Re: Project Solis —Tract J Bulk Land Plat for Mesa del Sol Innovation Park II (101605115947920604)
Project No: PR-2022-007805 (Third Submittal); SP-2025-00084
EPC Plan No: FP-2025-00004

On behalf of Project Solis, Stantec Architecture Inc. respectfully submits this supplemental submission of minor design revisions for final DFT review and approval. The proposed substitutions adhere to the preliminary approvals and findings stated in the EPC *Official Notice of Decision*, dated Aug. 21, 2025 (Plan# FP-2025-00004), and remain in full compliance with the City of Albuquerque IDO codes and regulations. The following revisions have been submitted concurrently to Mesa Del Sol ARC for Step II amendment review and approval.

SHEET NUMBER
A-201

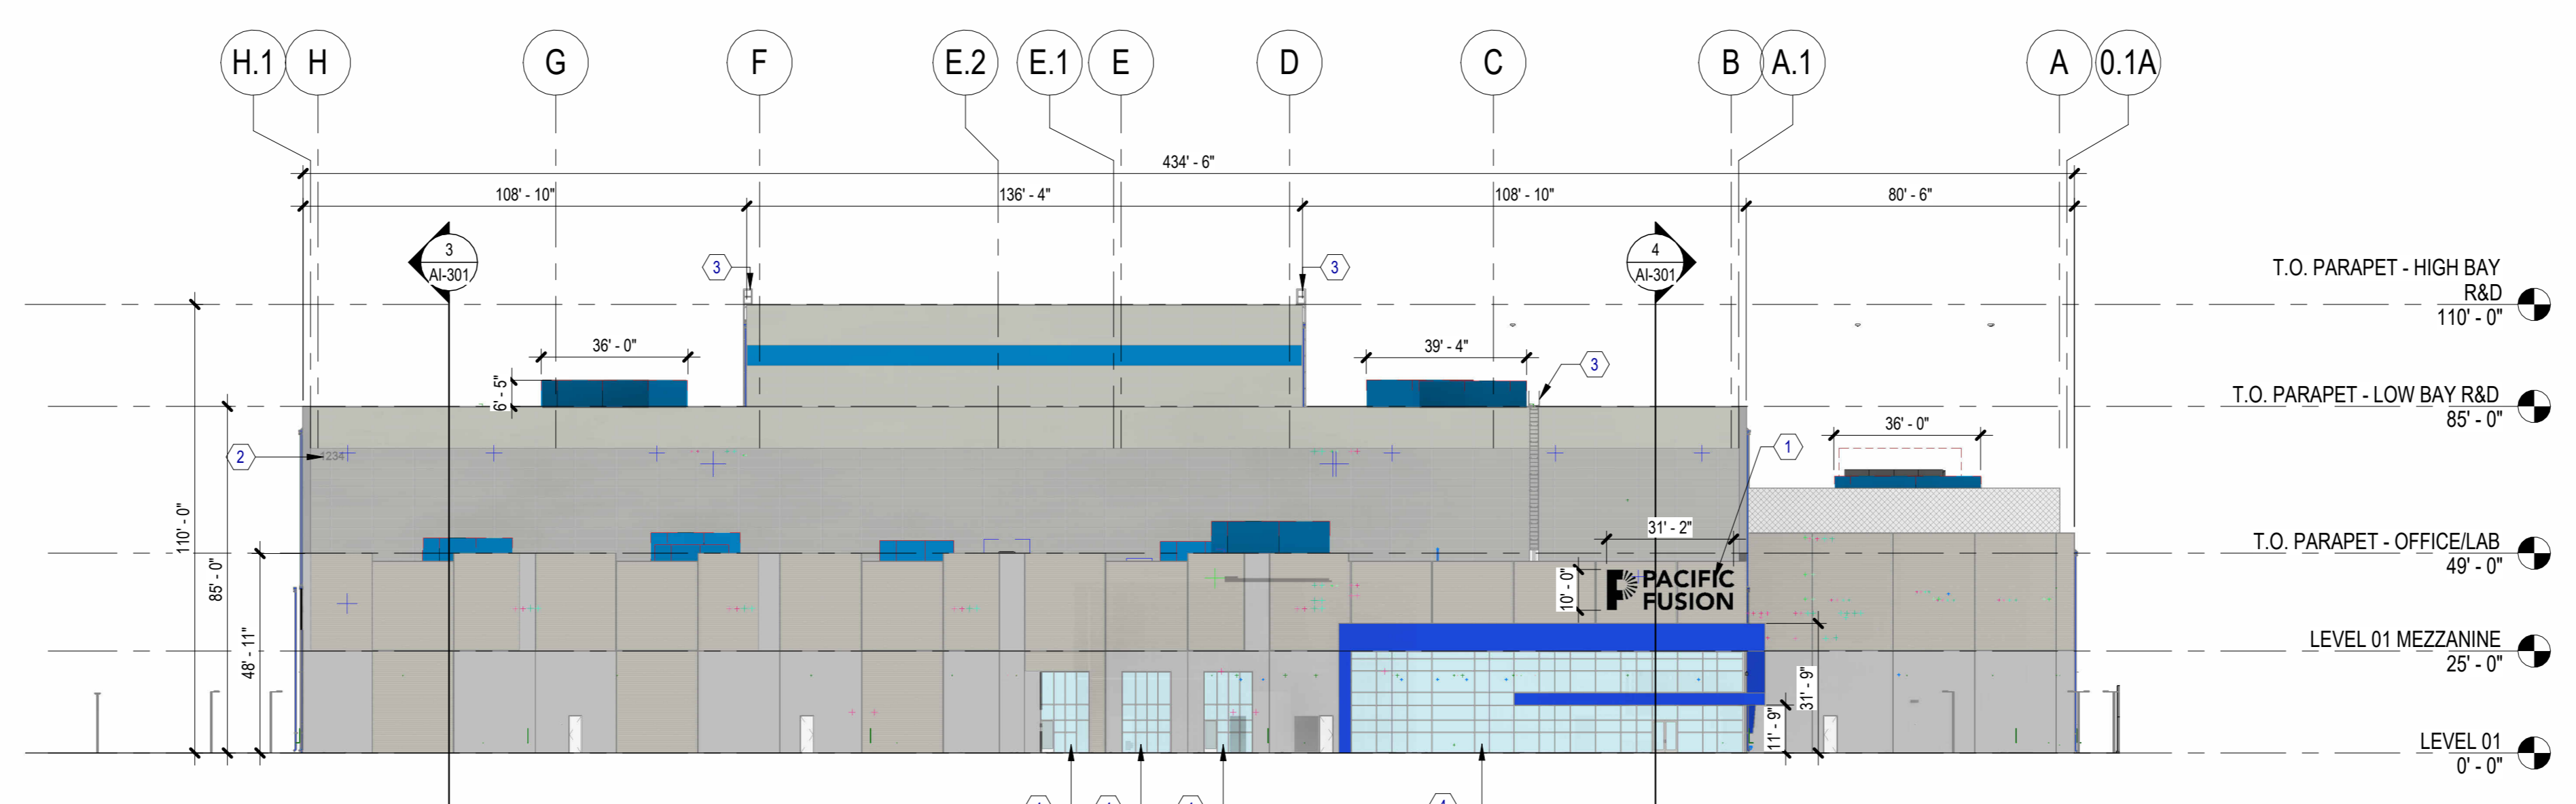
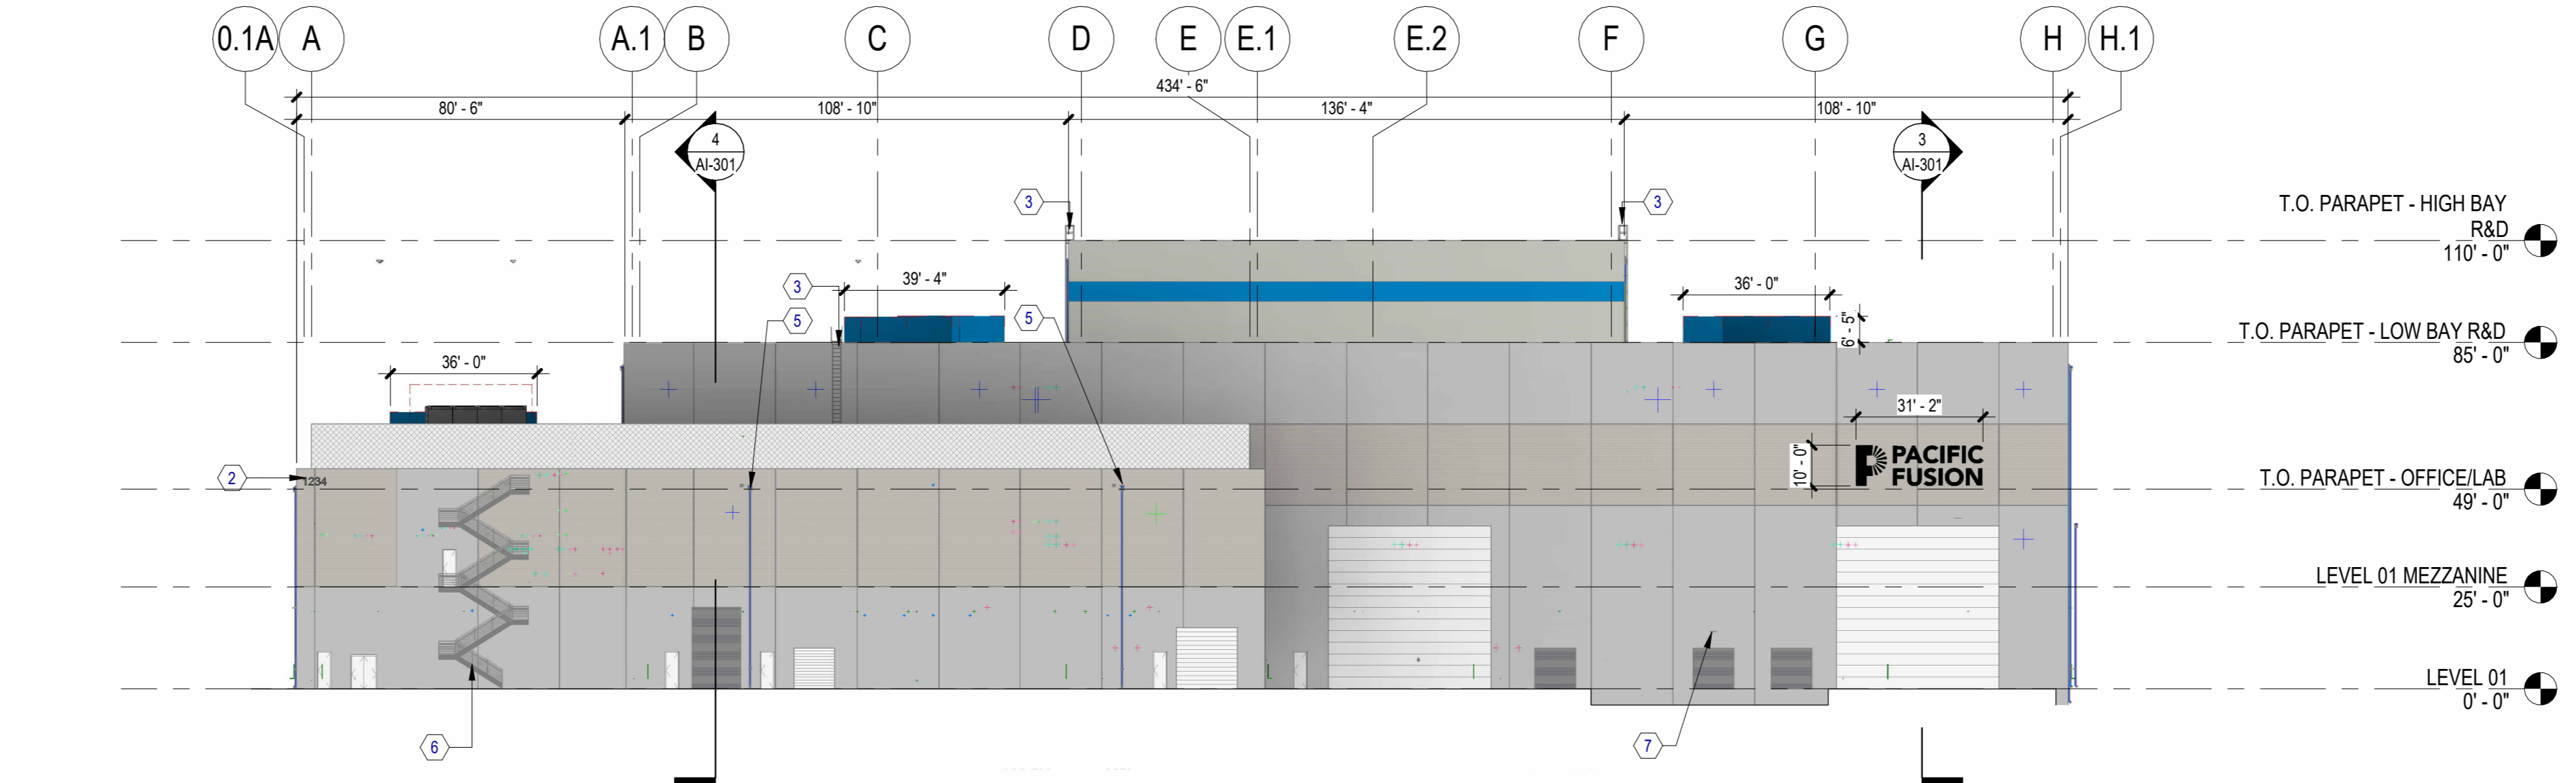
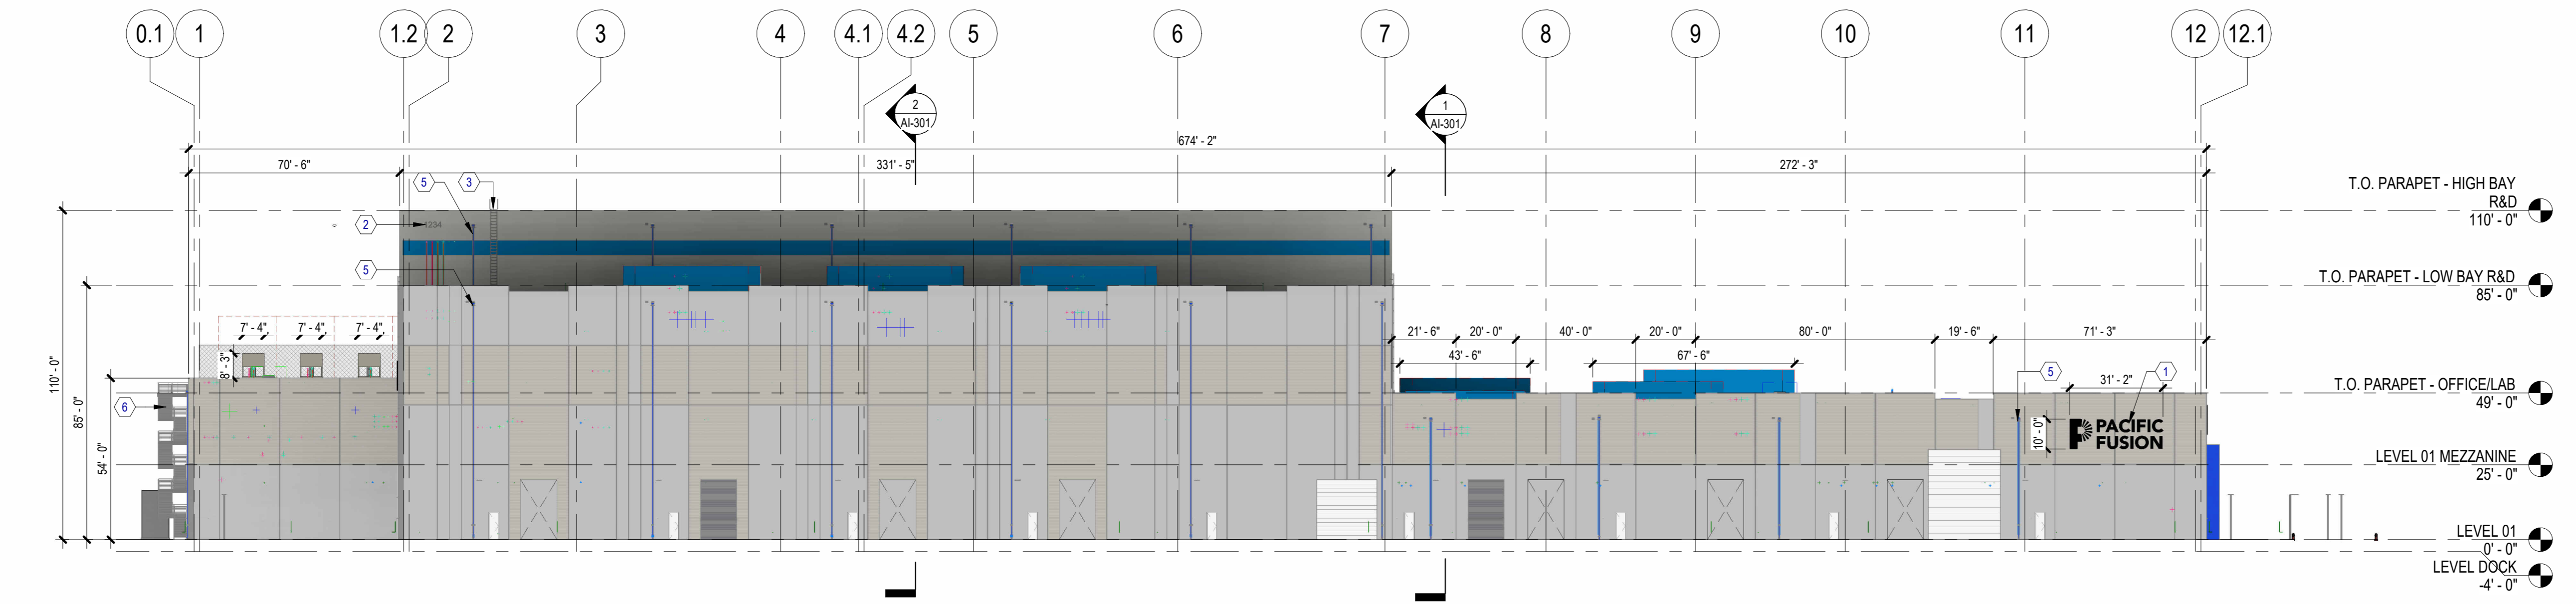
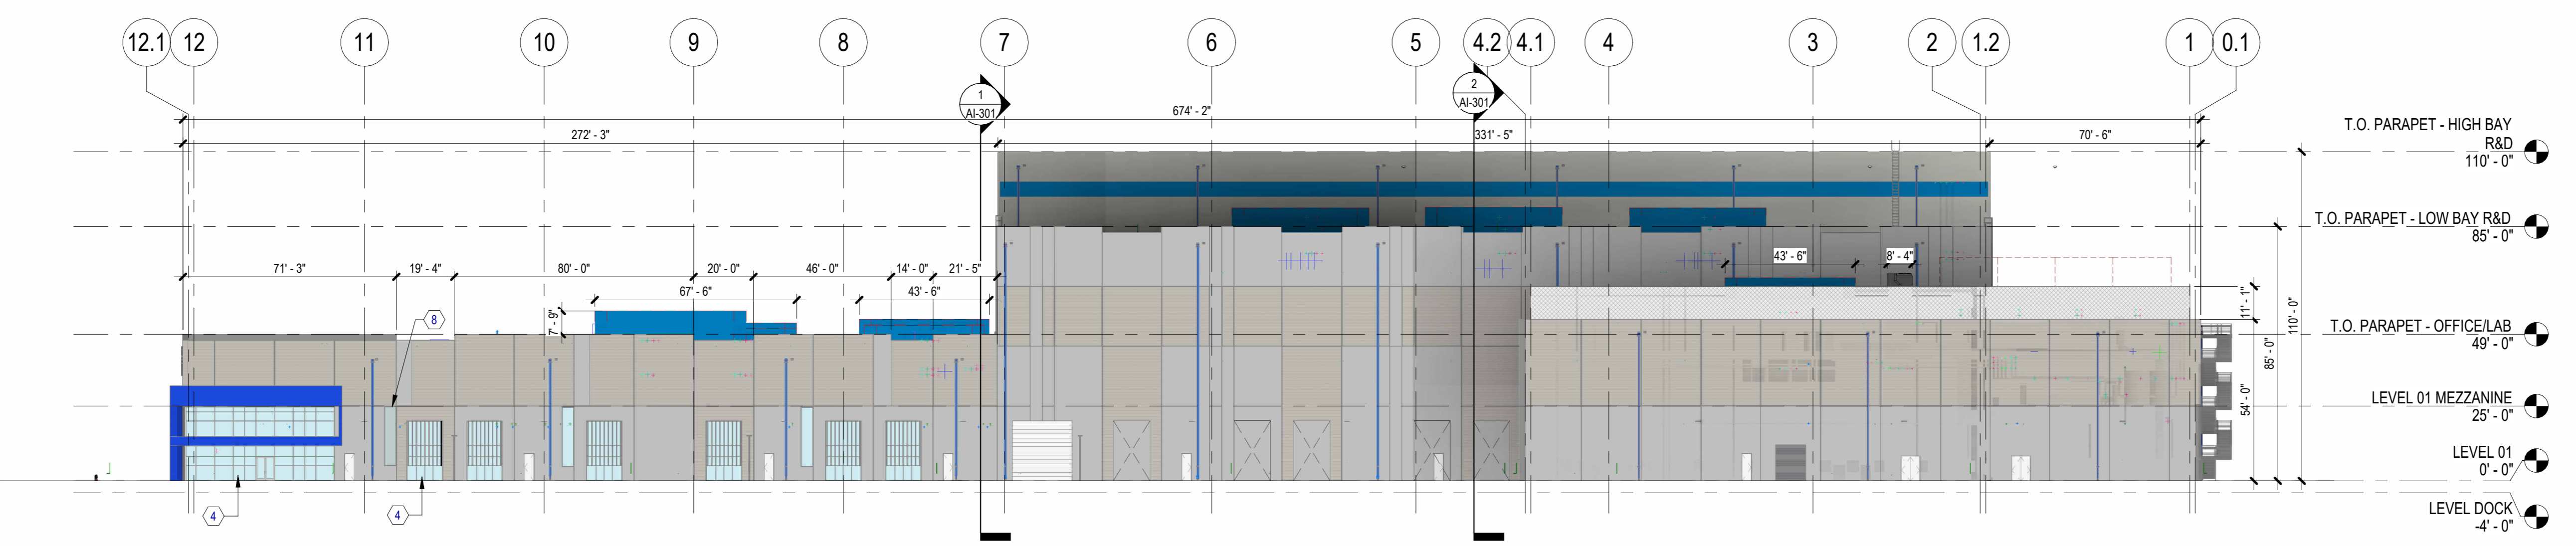
Overall Building – The drawings have been revised to reflect new, relocated or removed openings, including, man doors, overhead doors, and windows. At the high bay, windows have been removed between grids 2 & 7. The revised design remains congruent with the originally approved design, and compliant with all code and zoning requirements.

CUB Facility – The drawings have been revised to reflect the expansion of the CUB facility at the southwest corner of the building, at grid lines A1 thru B4.2. The expansion increases the gross floor area (GFA) from 225,795 sf. to 239,464 sf. a (6% increase). The height of the CUB facility walls also increased from 45' to 54', and equipment screening has been added around the perimeter of the CUB roof to screen rooftop equipment.

SHEET NAME
 ELECTRICAL PHOTOMETRICS SITE
 PLAN

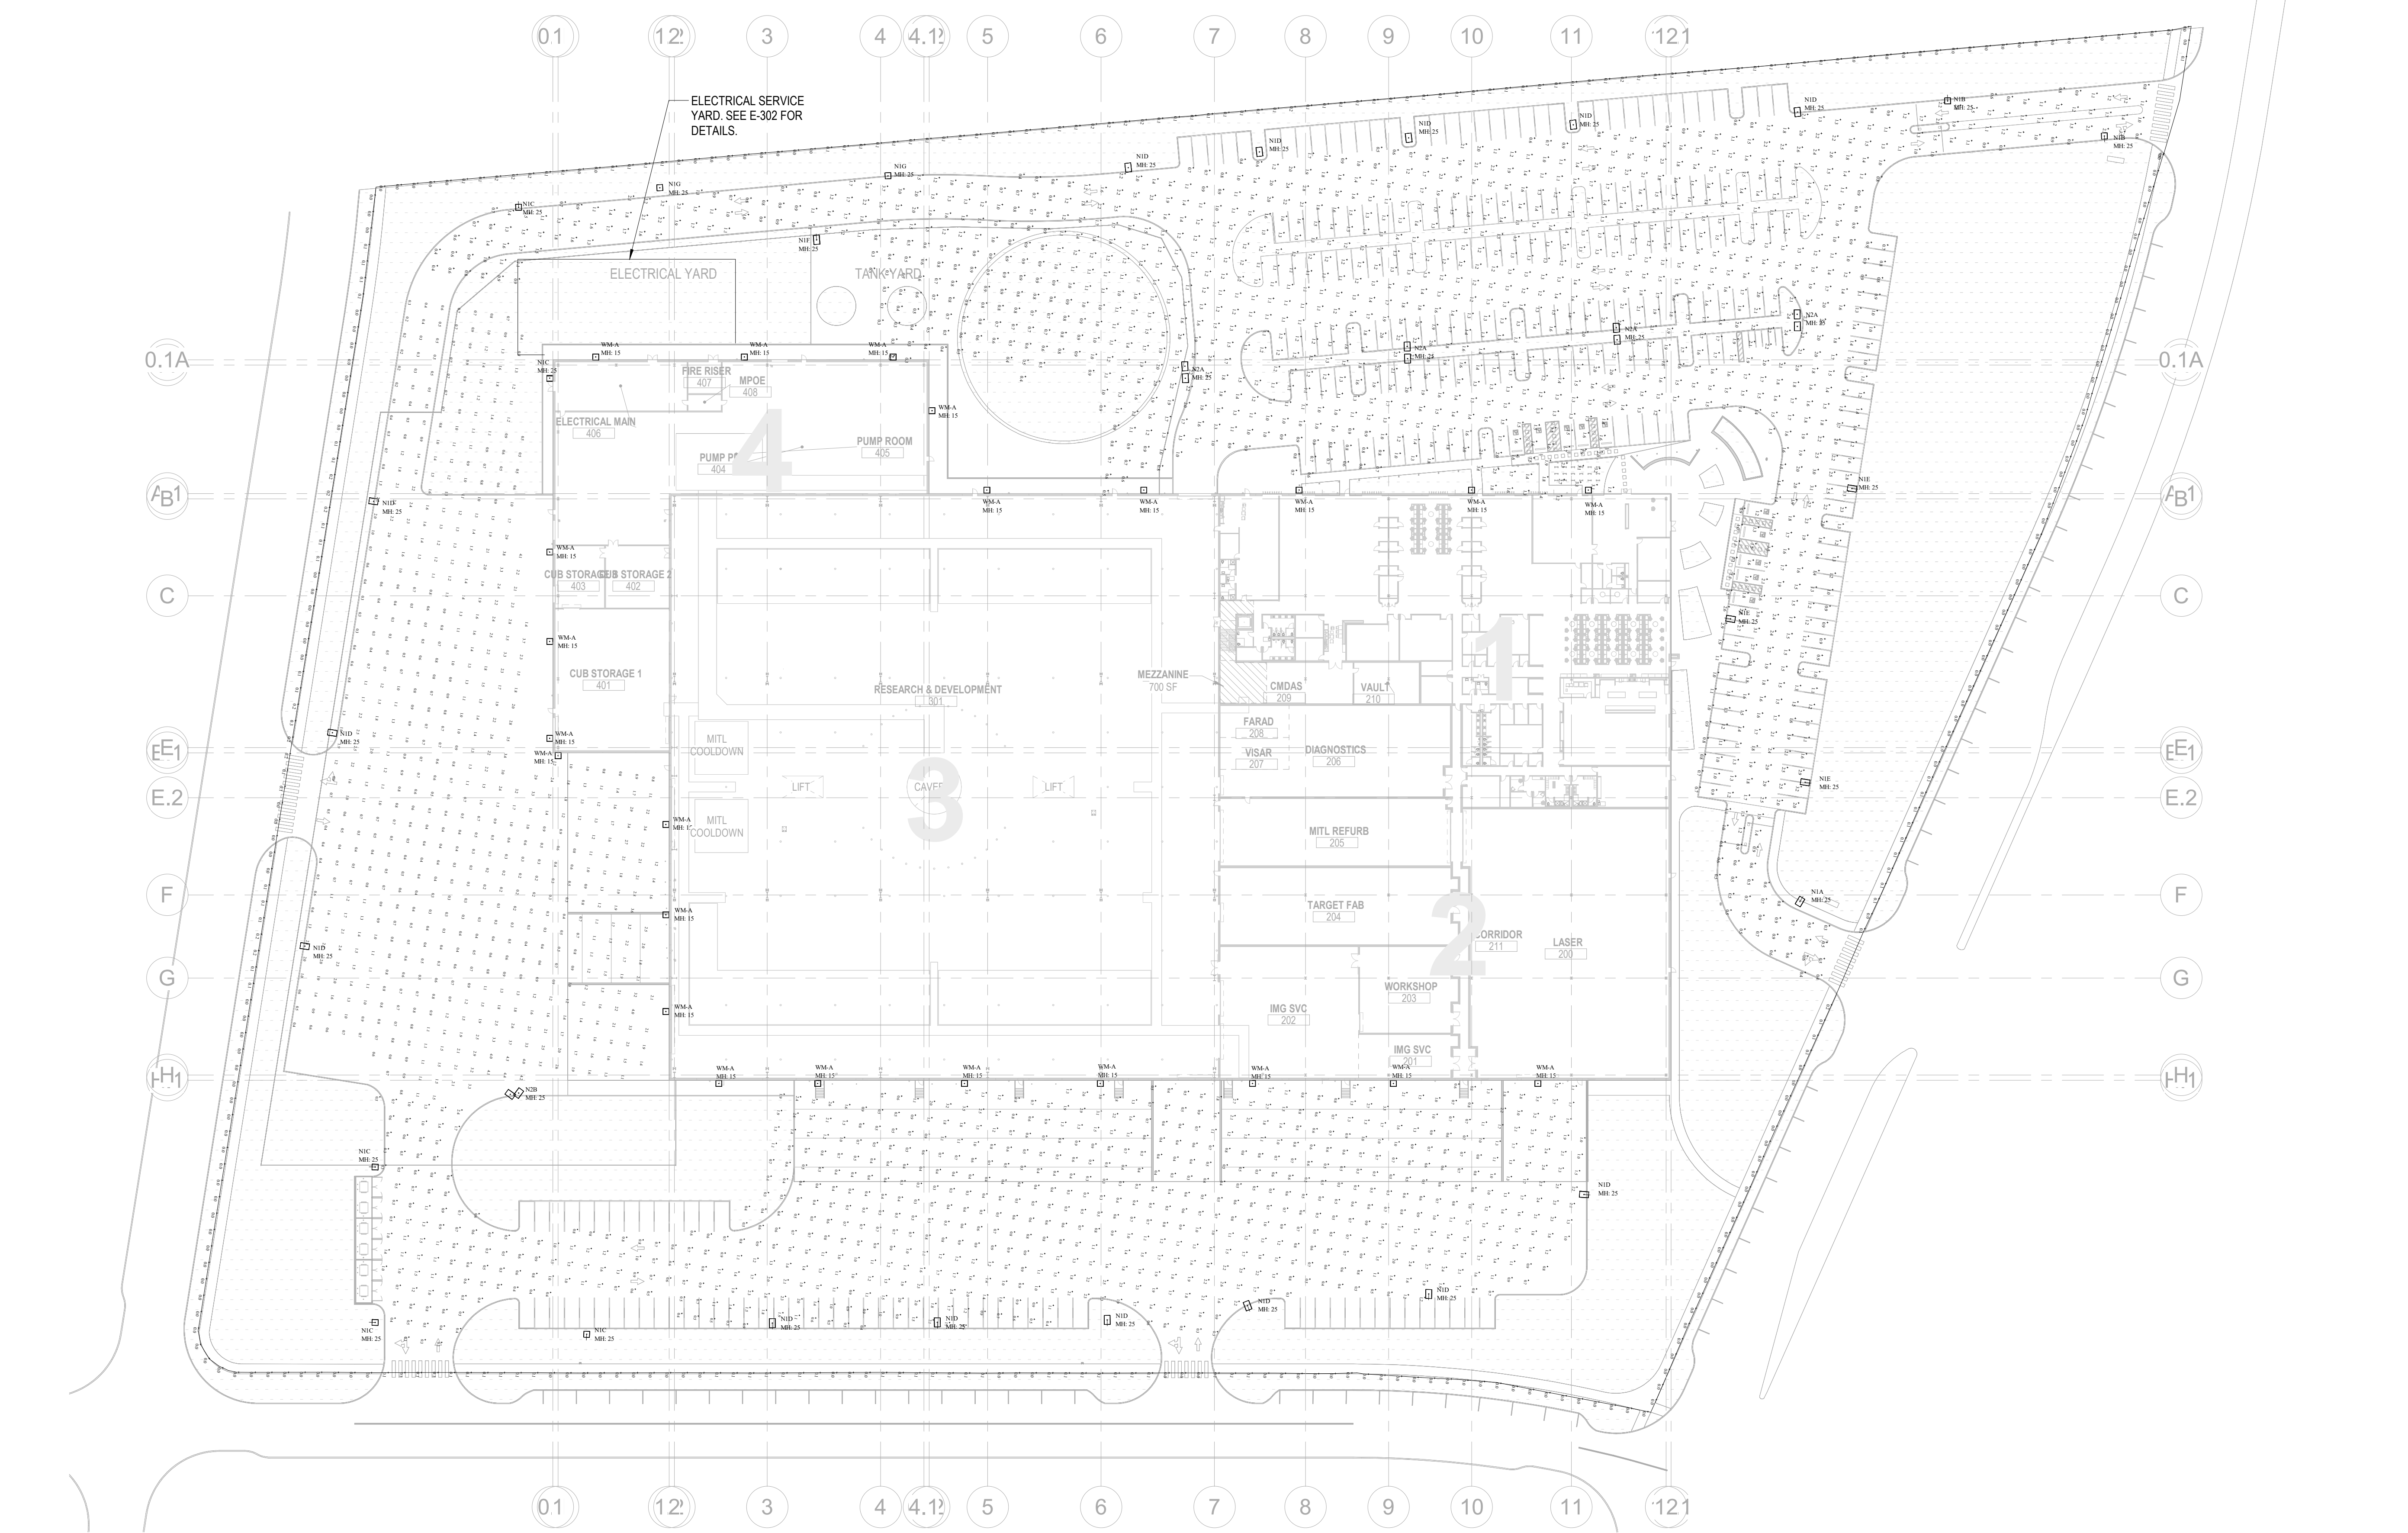
Site Lighting – The site lighting has been adjusted to match the minor modifications to the overall site design.
